Application no: **3/2023/0248**

Address: **Highfield Garstang Road Chipping PR3 2QH**

Proposal: **Proposed replacement dwelling.**

The Local Highway Authority have viewed the plans and highway related documents and have the following comments to make:

name
Proposed Plans, Site and Elevations

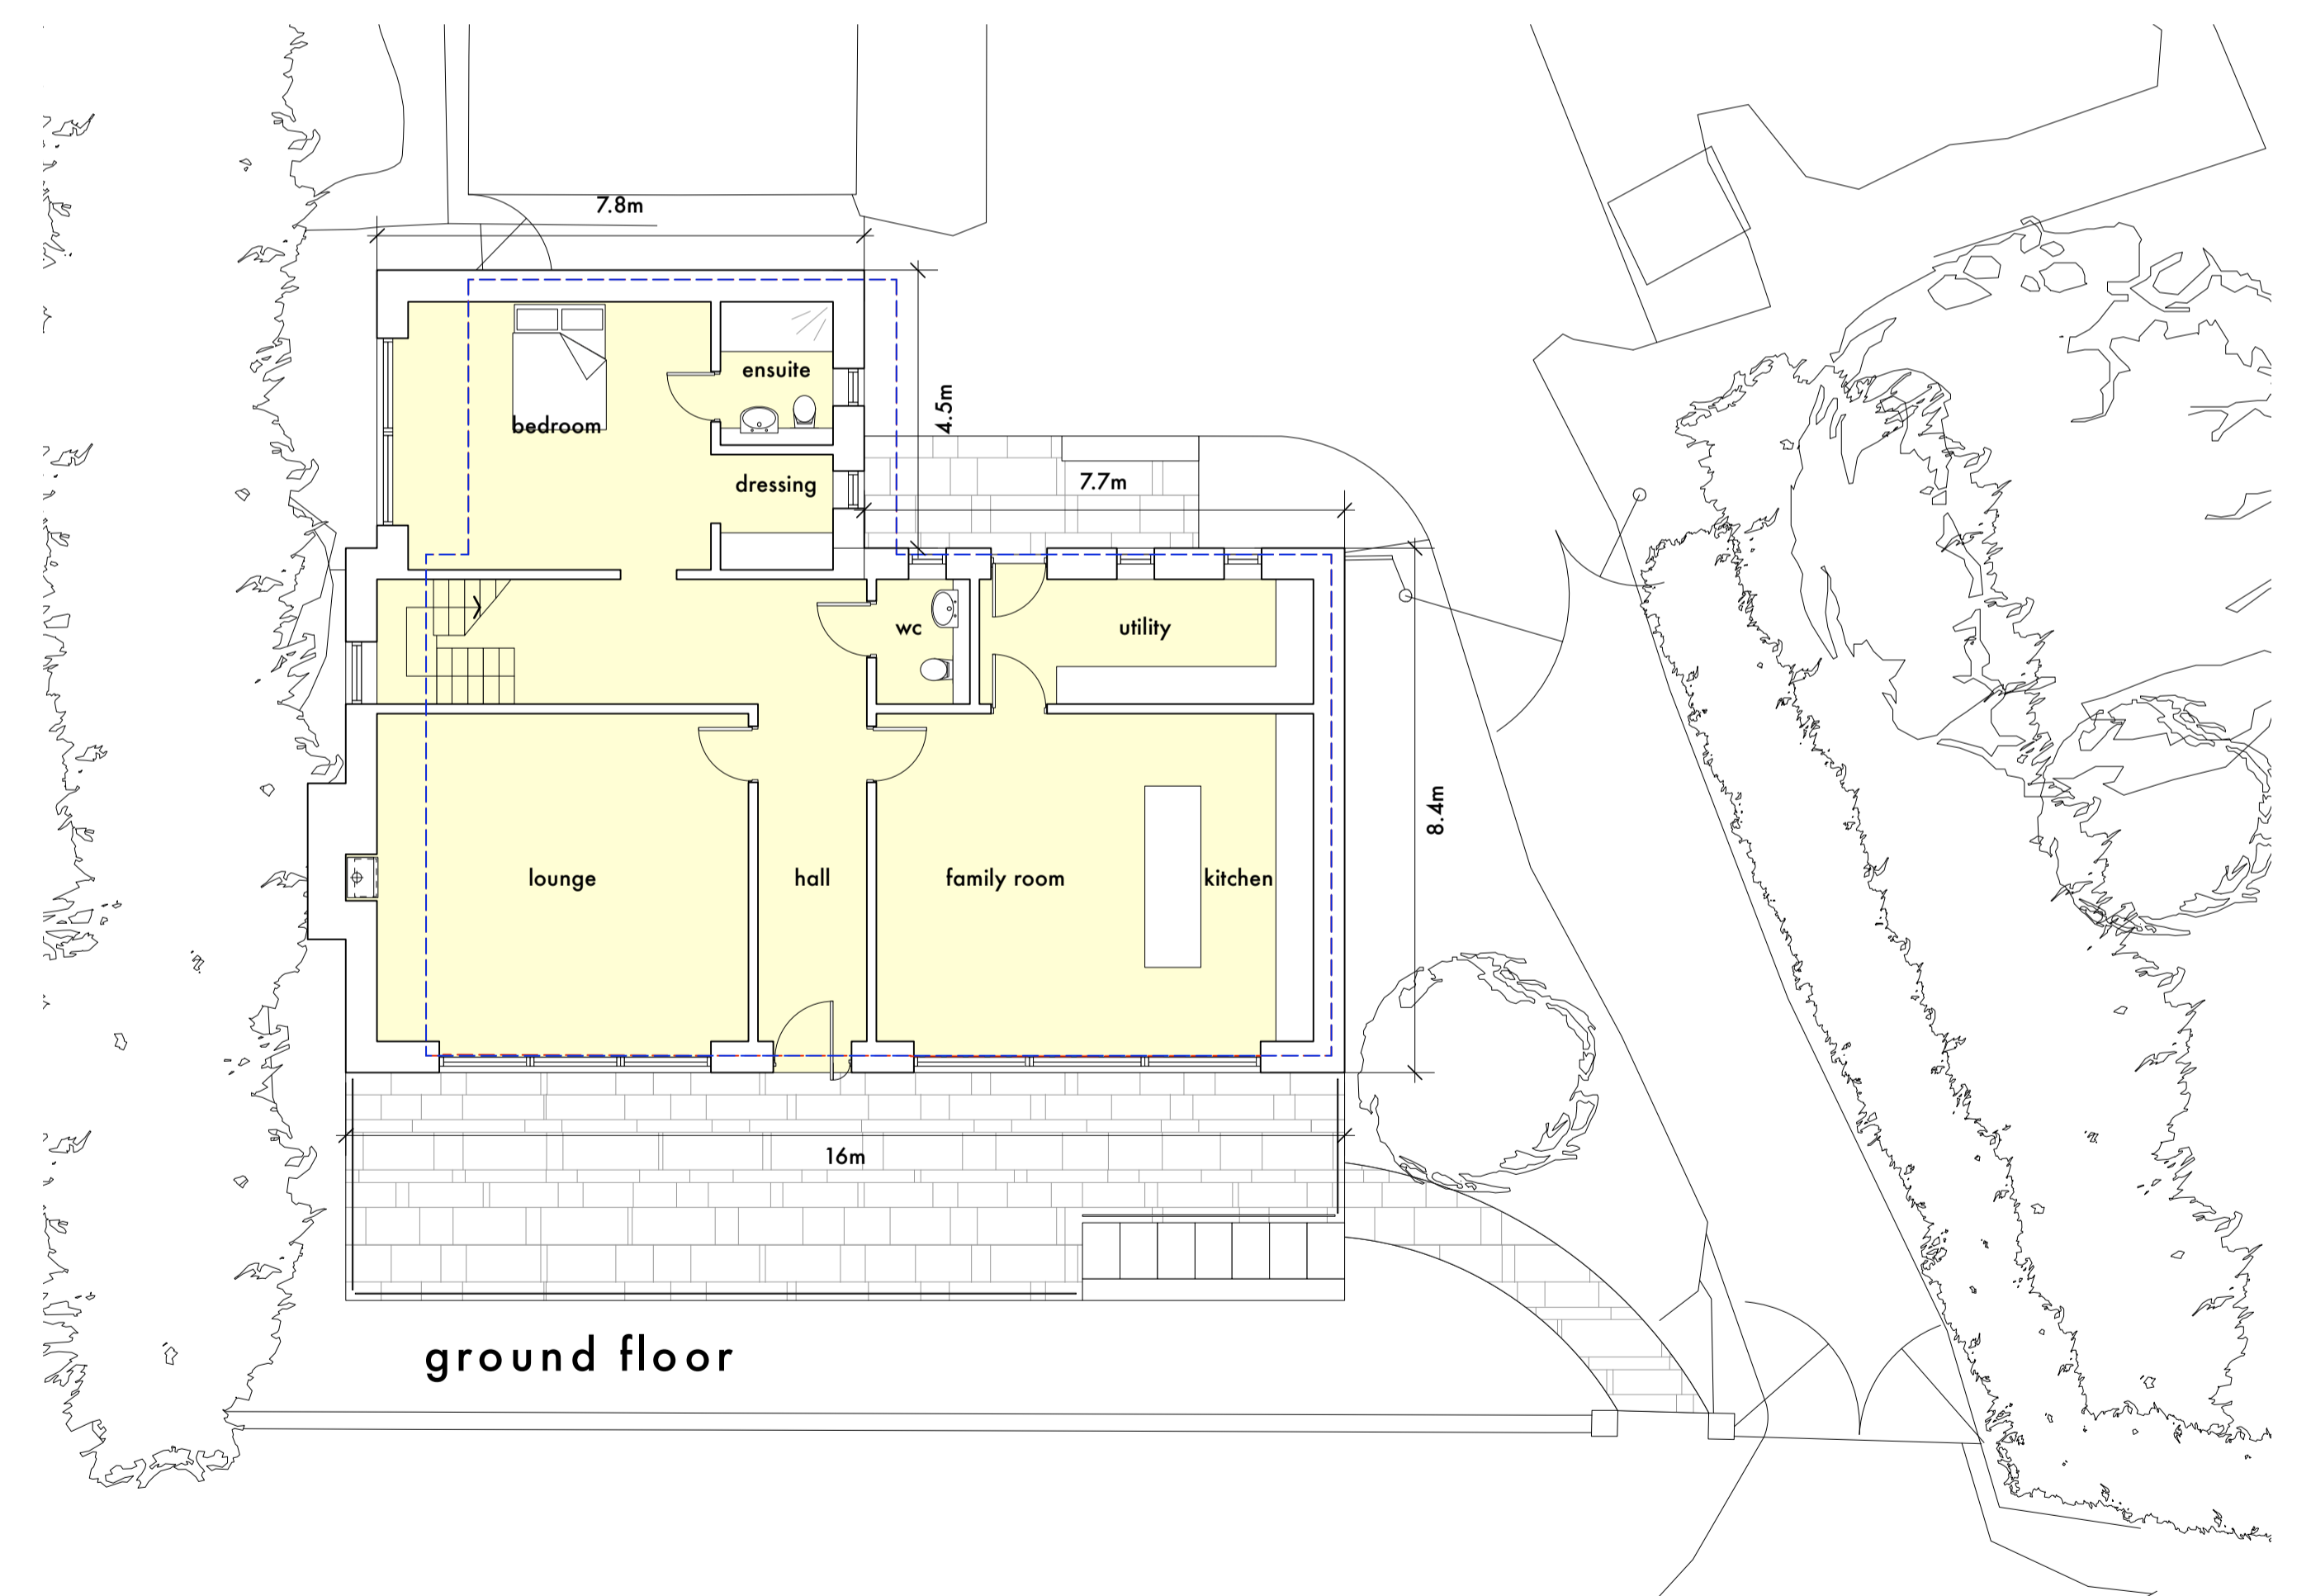
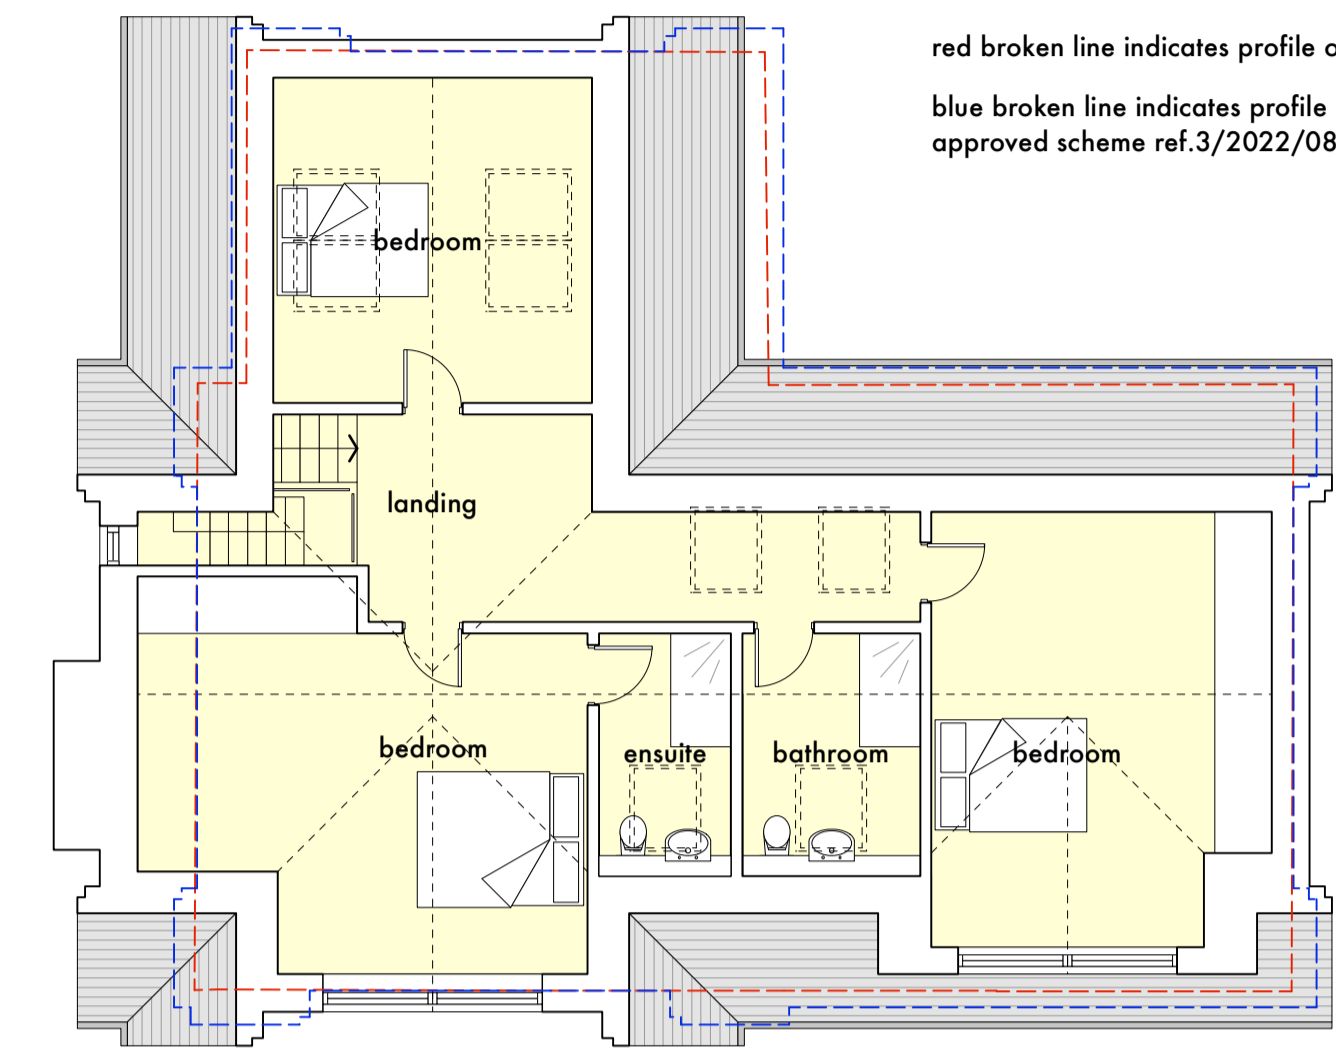
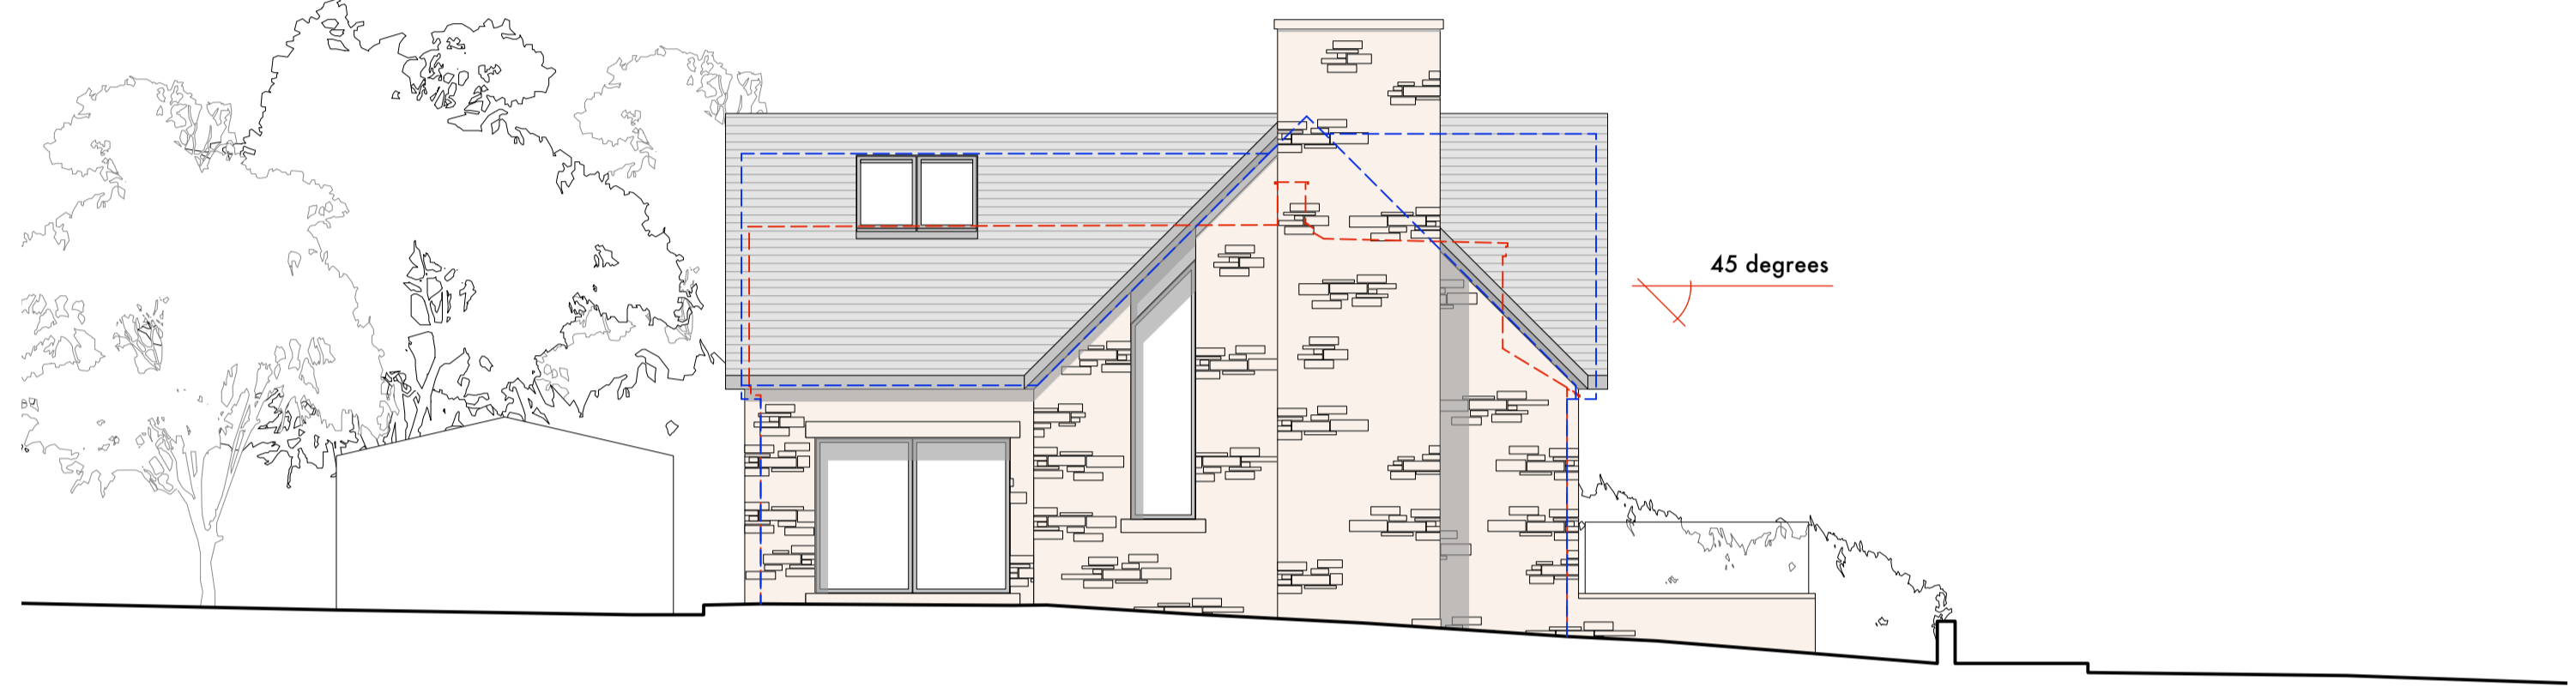
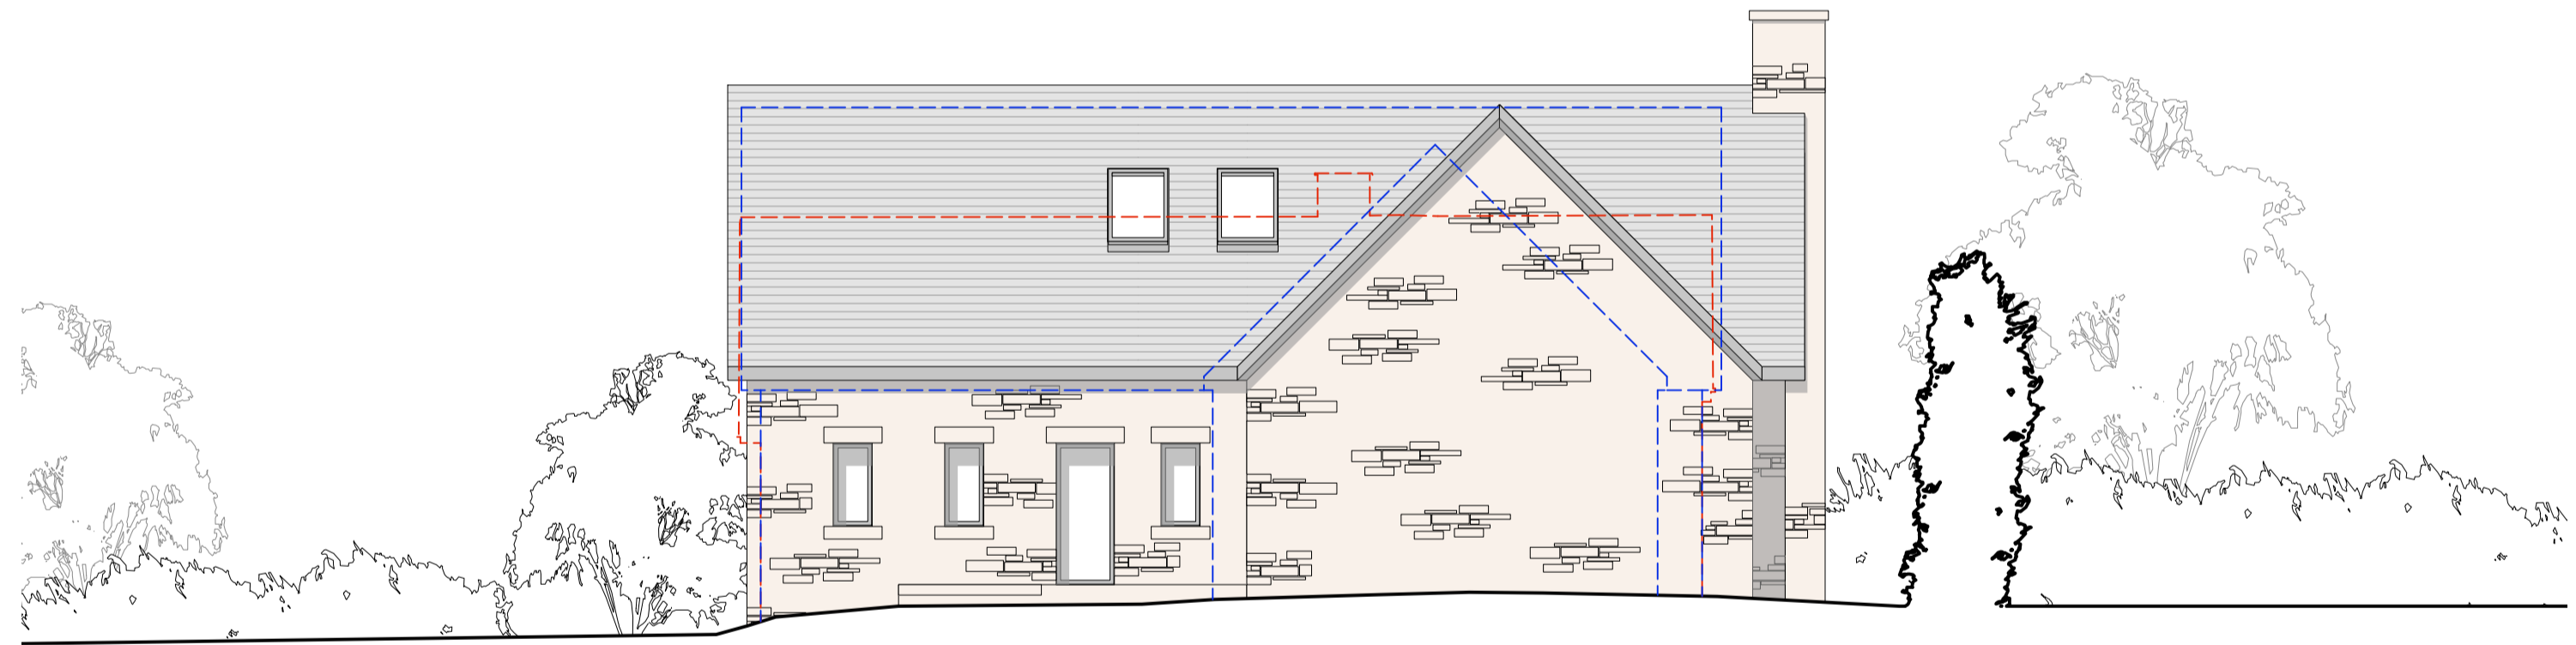
The LHA have reviewed Stanton Andrews drawing number PL.10 Rev B titled "Proposed Plans, Site and Elevations" and are aware that the proposed access arrangements will remain as existing. Therefore, with the access already serving the dwelling, the LHA have no further comments to make.

The LHA have reviewed Stanton Andrews drawing number PL.10 Rev B titled "Proposed Plans, Site and Elevations" and are aware that the parking arrangements for the 4-bed dwelling will remain as existing. Therefore, since the dwelling is already a 4-bed property, the LHA have no objection to the proposal.
